DESCRIPTION OF REQUEST: DRB FINAL SIGNOFF OF SITE PLAN FOR BUILDING PERMIT

**RE: Paradise View Universal Apartments  
lot 12A Paradise Hills Investment Properties  
Site plan for building permit  
EPC final signoff**

Rio Grande Engineering requests DRB approval of the enclosed site plan for building permit. This plan was approved with conditions by the EPC on August 12, 2016. An appeal of this approval was denied by the approval upheld by the city council on November 7, 2016 (AC-16-13). We have revised the plans to address the conditions. Below is the list of conditions with the resulting corrective actions taken underlined.

ENGINEER'S SEAL	PARADISE VIEW UNIVERSAL APARTMENTS	DRAWN BY WCUJ
	CONCEPTUAL MASTER UTILITY PLAN	DATE 4-03-08
 Rio Grande Engineering 1606 CENTRAL AVENUE SE SUITE 201 ALBUQUERQUE, NM 87108 (505) 872-0888		2511-EPC-3-25-08X
		SHEET # 3 OF 5
DAVID SOULE P.E. #14522		JOB # 2511

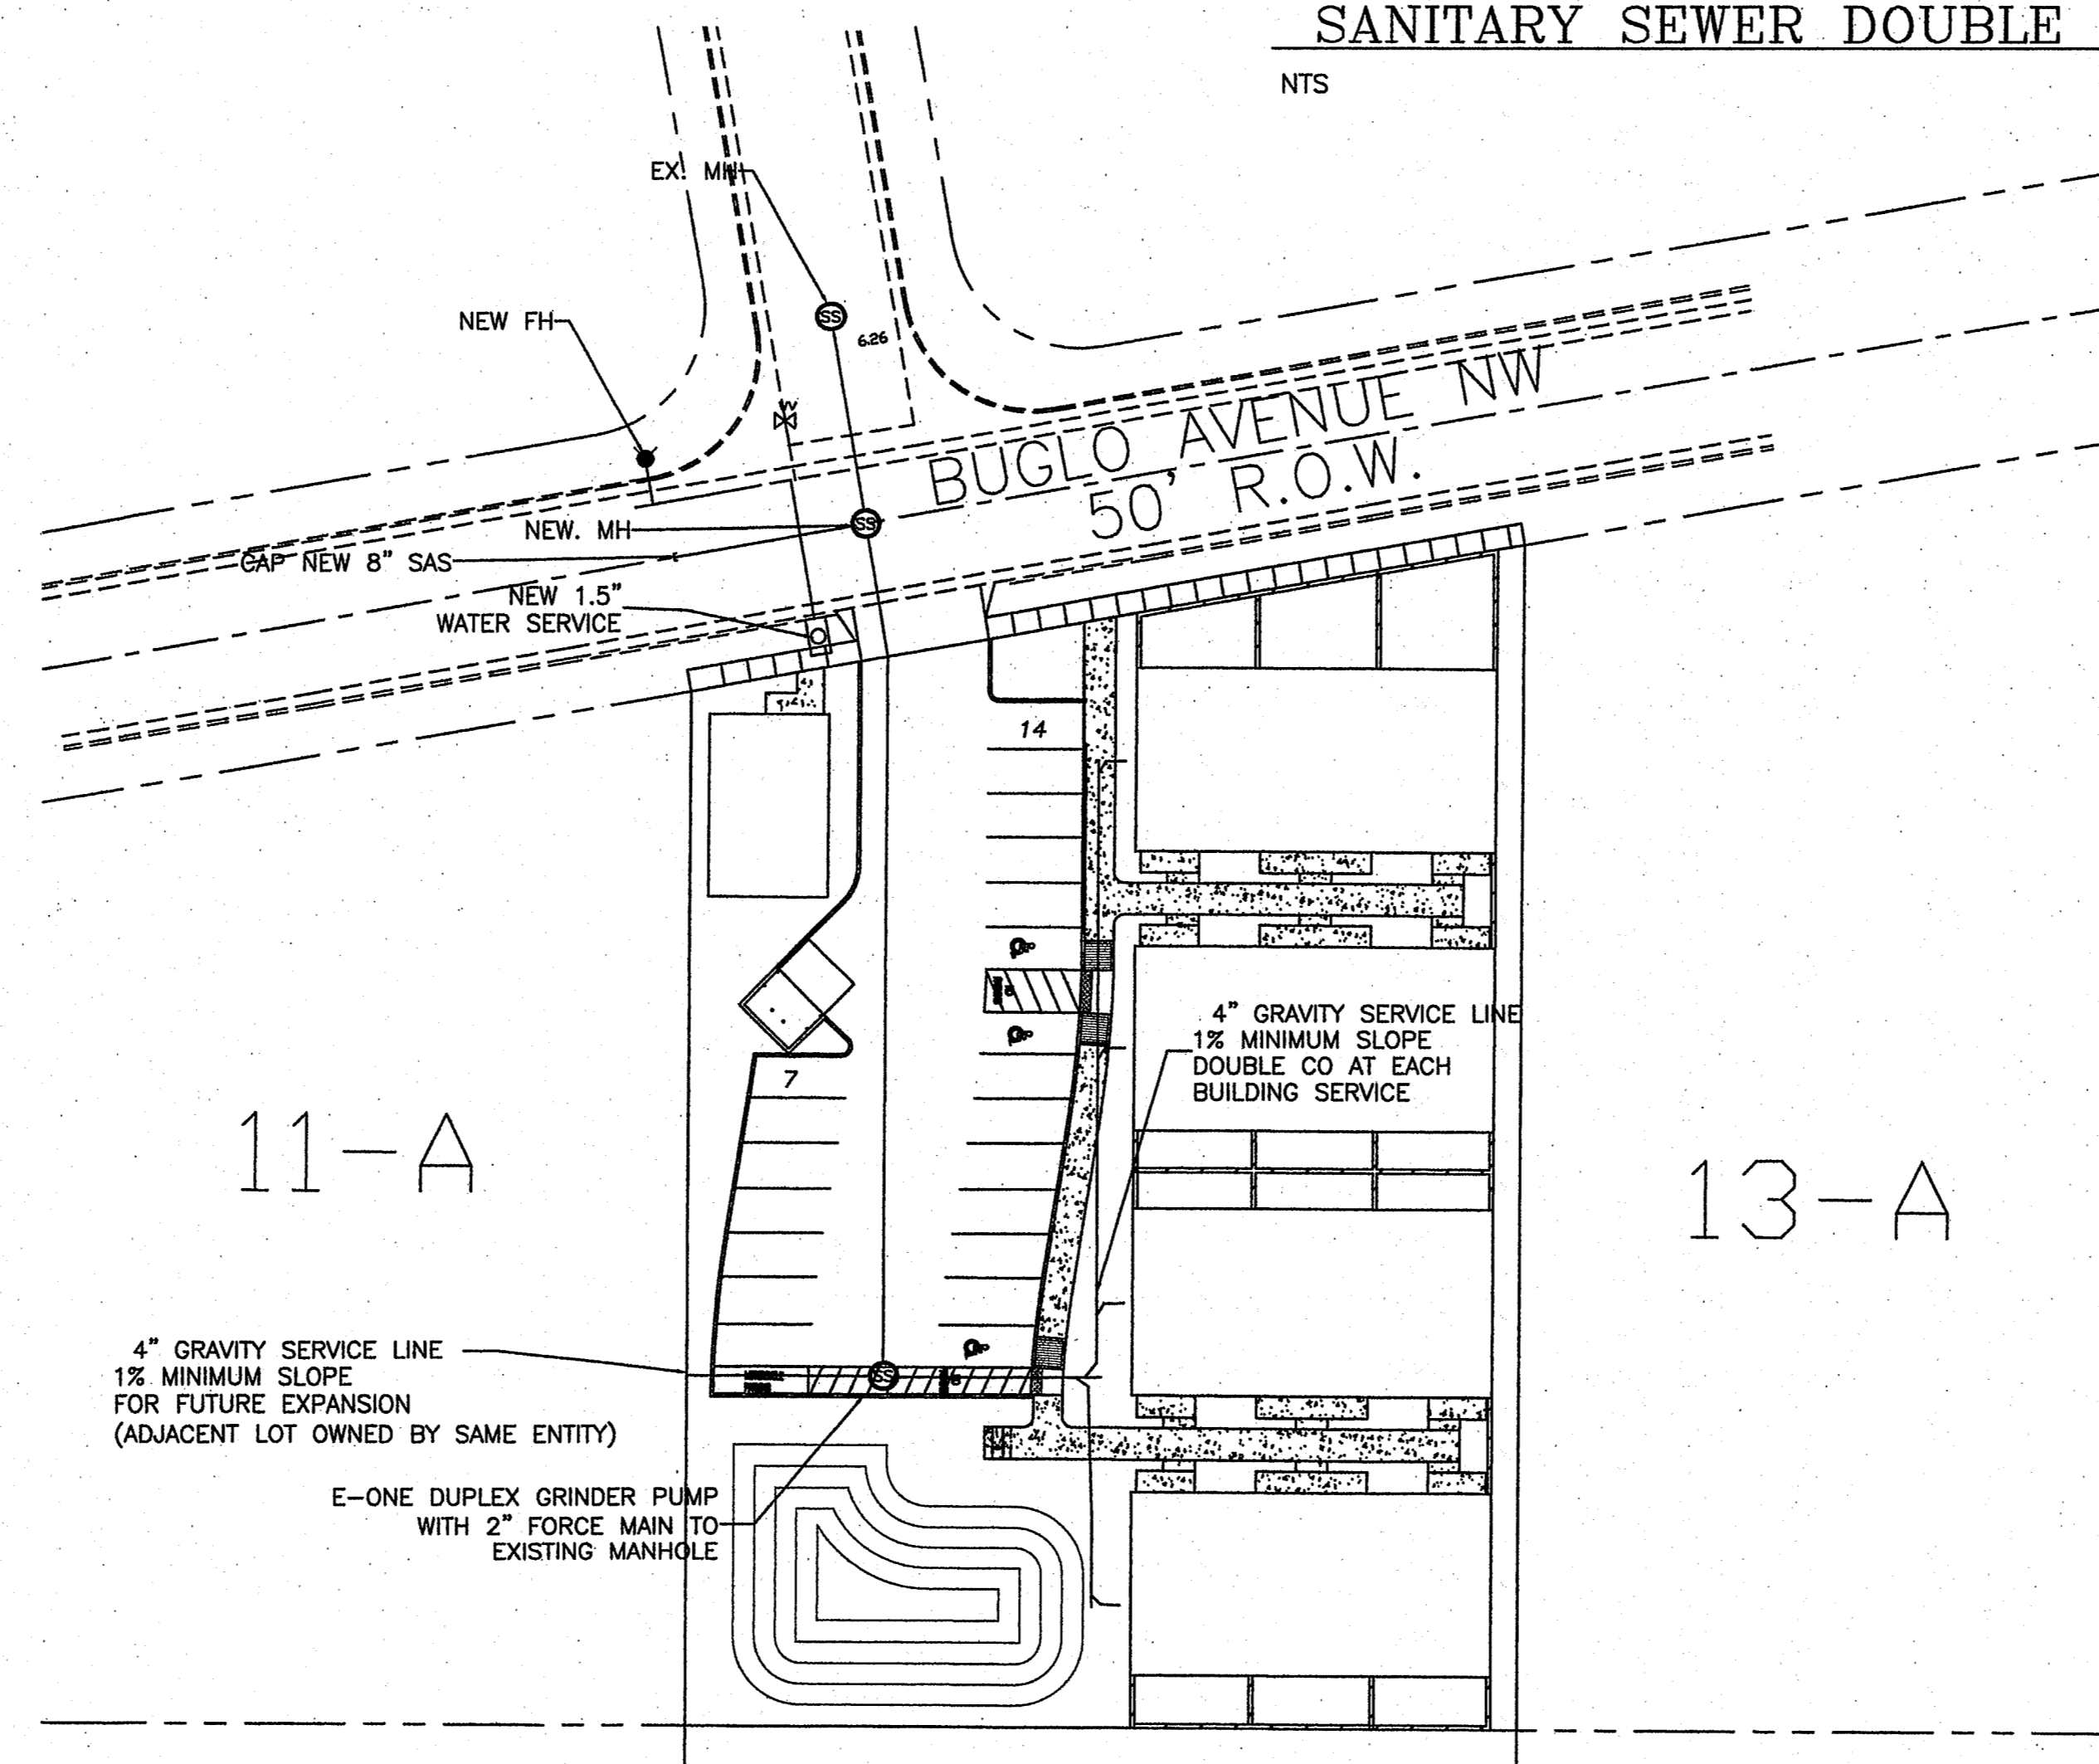
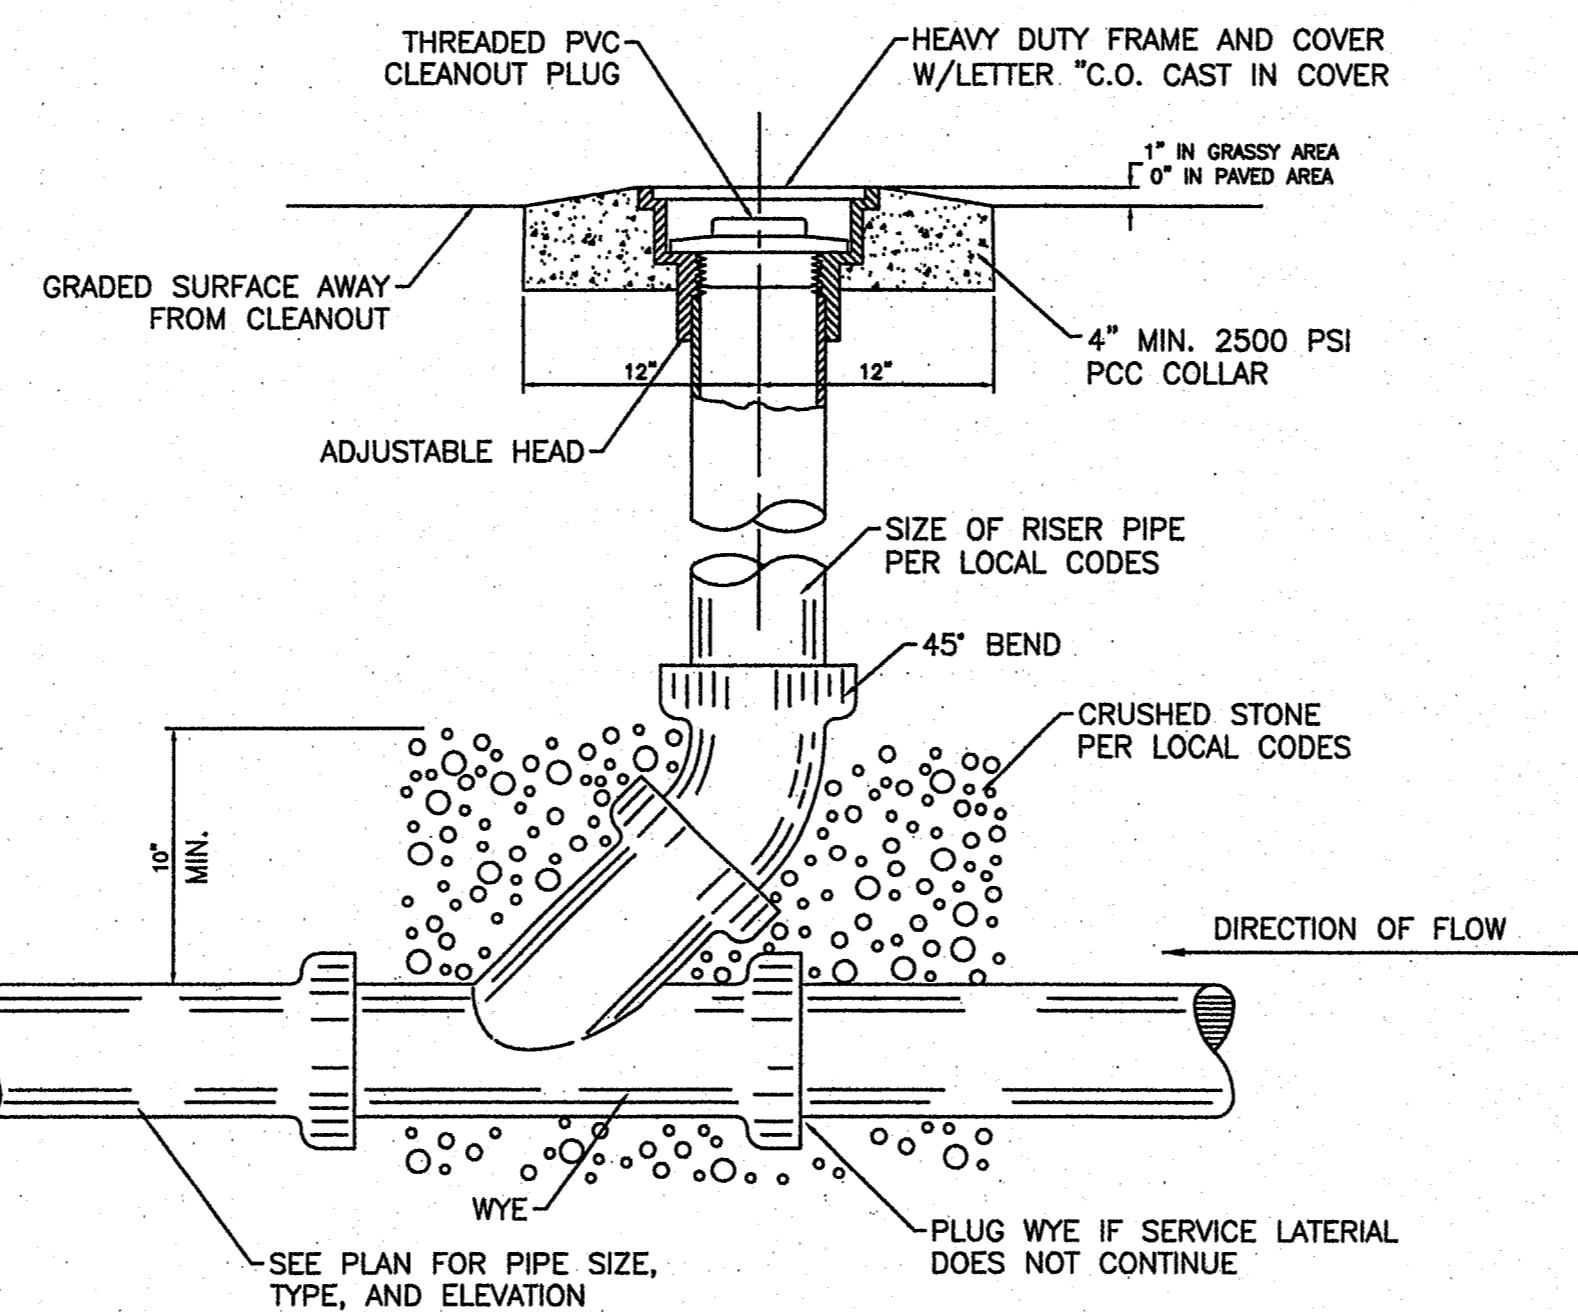
- C. Extension of waterline is required to cover the property frontage. This is required to allow for future extensions for the properties to the west.

- D. The utility plan indicated a private grinder pump for discharge into the exiting manhole along Sierra Morena St. This may not be acceptable as a public sanitary sewer extension (force main) may be required to cover the property frontage. The requirements will be determined by the serviceability statement

We have shown this extension in addition to a new fire hydrant

We have modified the plan to show a public gravity line extension upstream

VIVA PARADISE – COMMON BUILDING  
ELEVATIONS INDICATING ROOF STRUCTURE, FINISHES AND DIMENSIONS

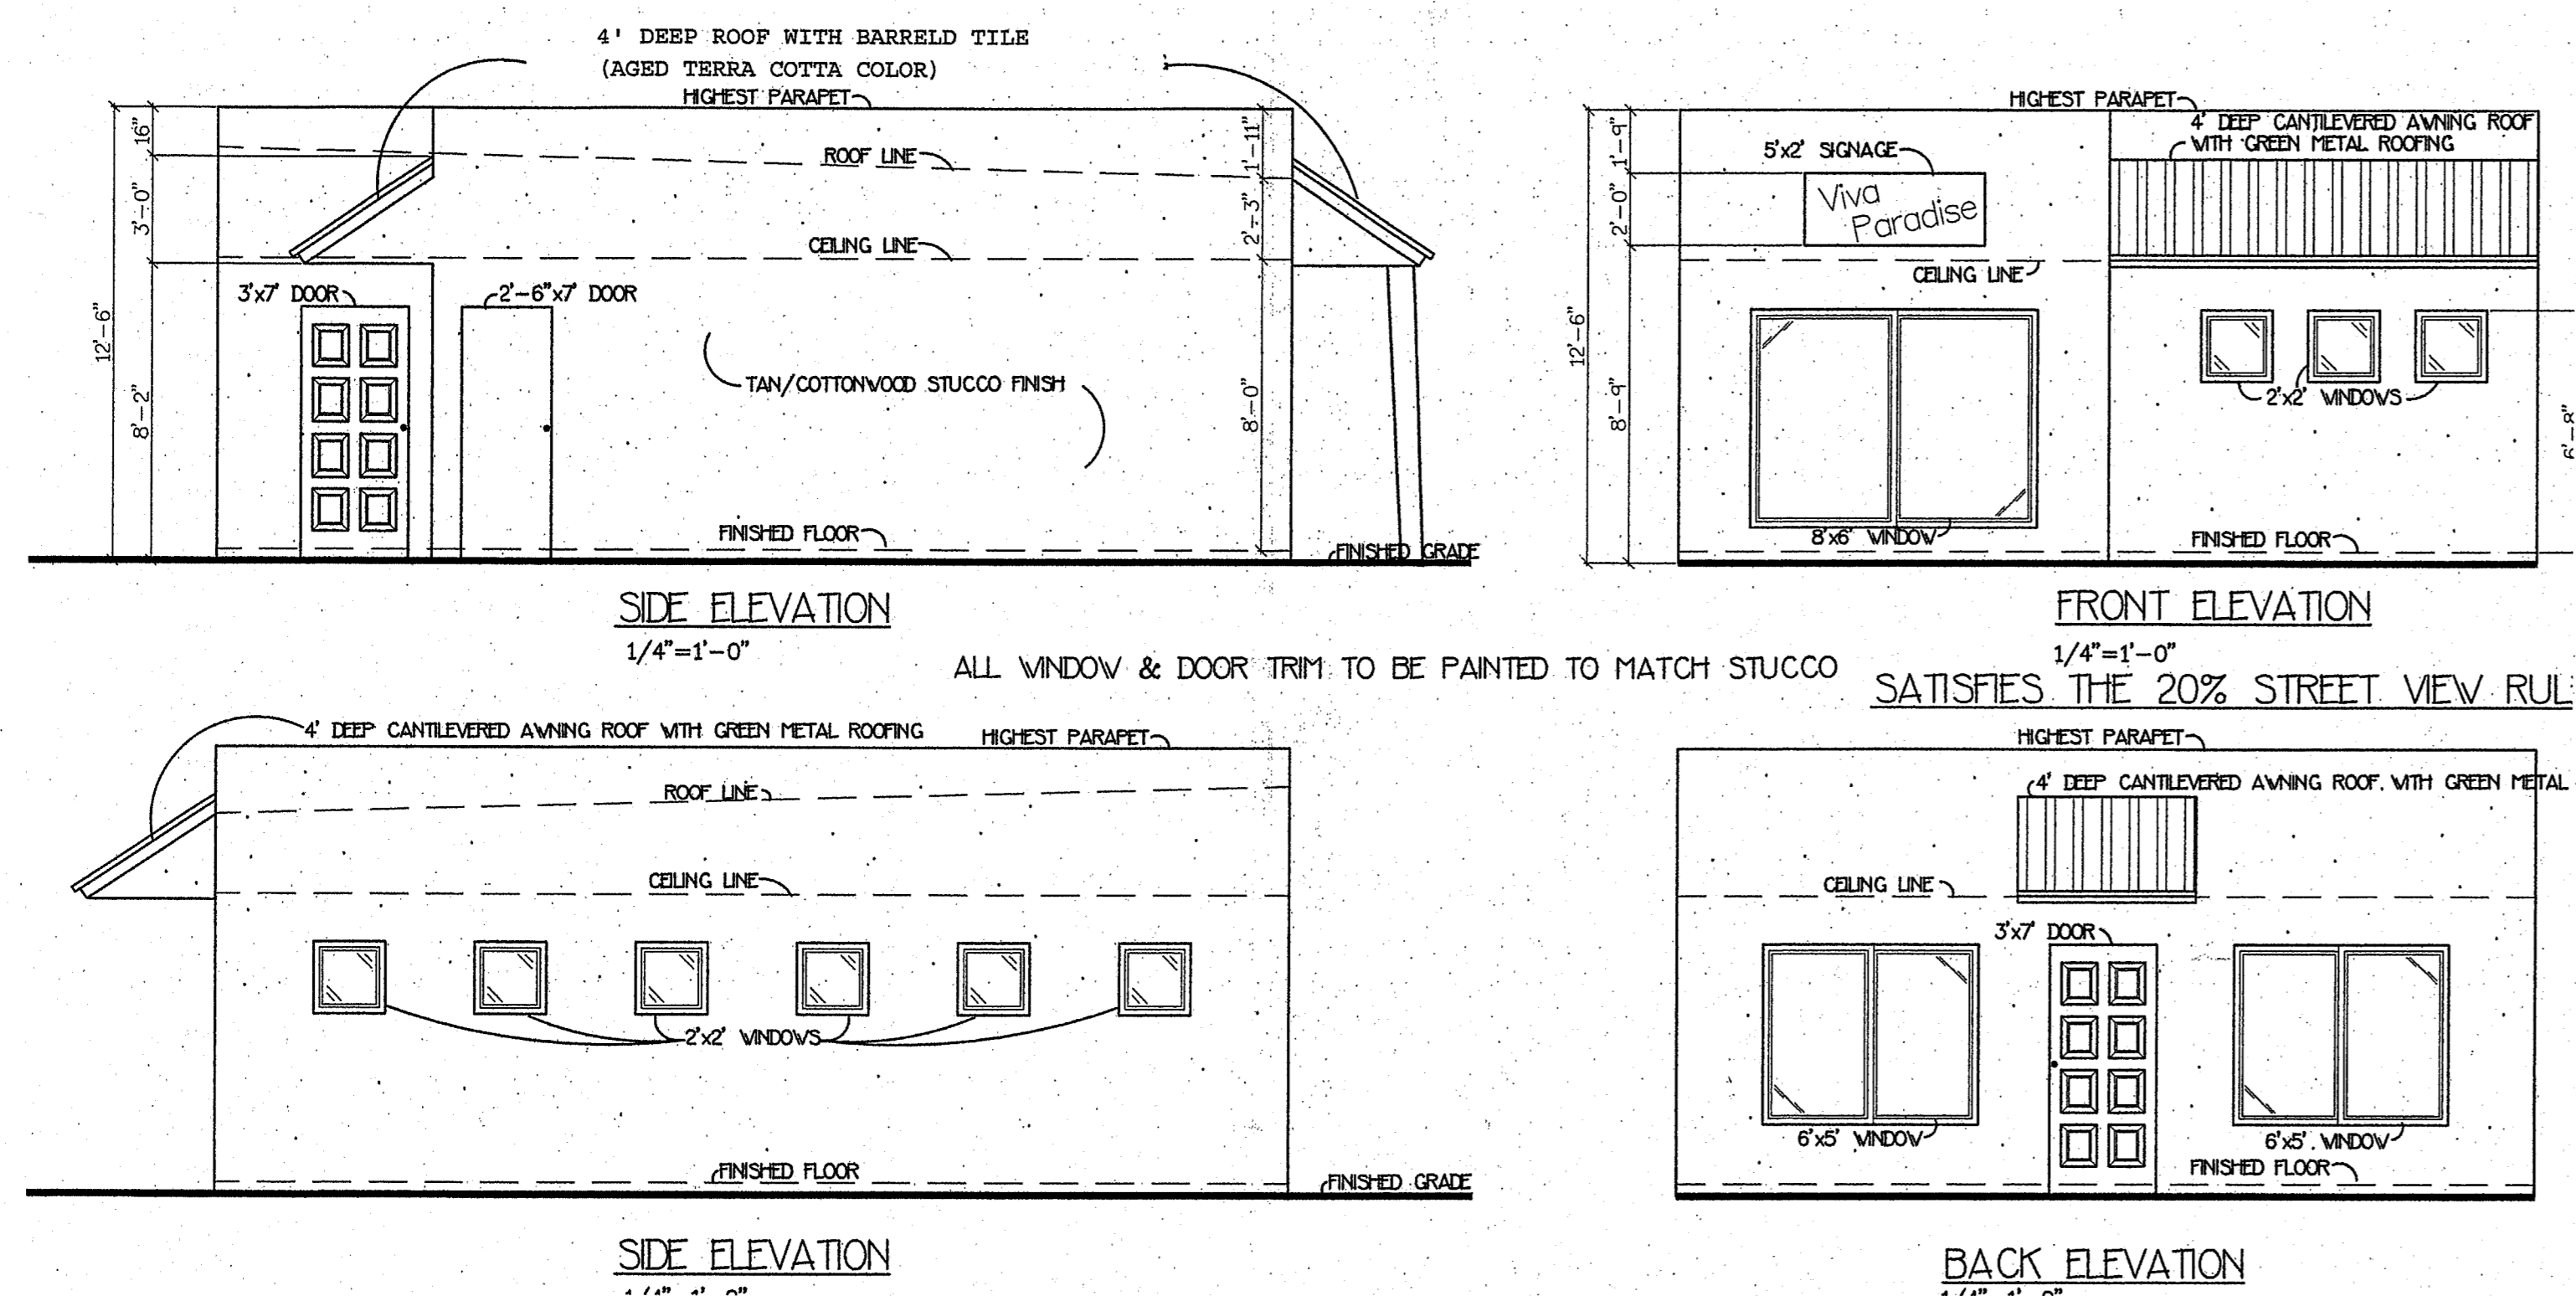
3. The proposed colors of the buildings including awnings shall conform to the color palate of the northwest mesa escarpment plan. A minimum of 2 additional architectural features or elements found in the surrounding neighborhoods shall be added  
We have labeled the colors. We have added (1) tile roof and (2) stucco posts to the front porches to satisfy this requirement the tile and posts are prevalent in the neighborhood
